Your ref:  
Our ref: 23/00007/F  
Please ask for: Mrs Lesley Raby  
Direct dial: 01553 616818  
E-mail: borough.planning@west-norfolk.gov.uk

Details: **Replacement timber shopfront with aluminium at Sue Ryder Care 79 Westgate  
Hunstanton Norfolk PE36 5EP**

Title:  
 SHOPFRONT DETAILS

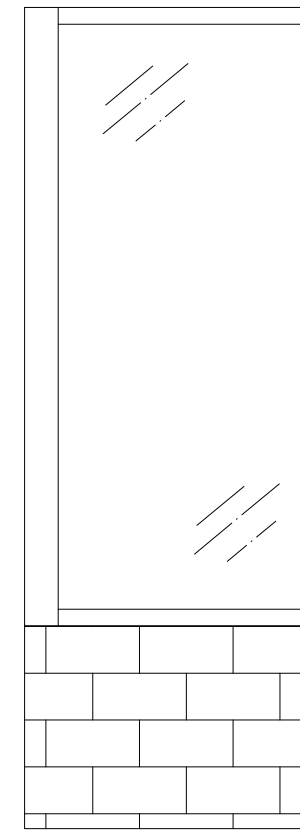
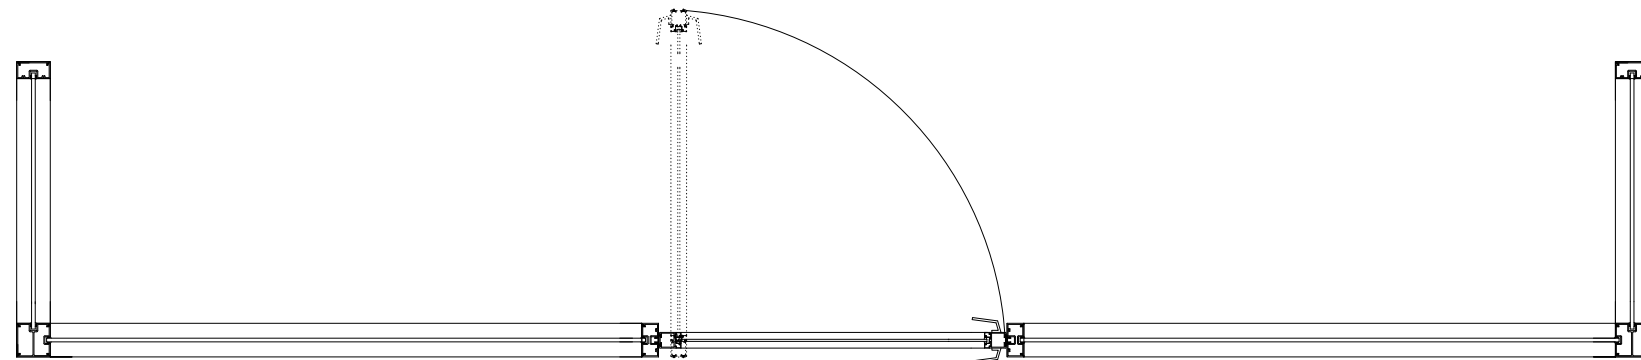
1. The proposed plan is not to scale.

Provide a proposed plan with is to scale at 1:100 and also confirm that both the existing side elevations and both the proposed side elevations are the same.
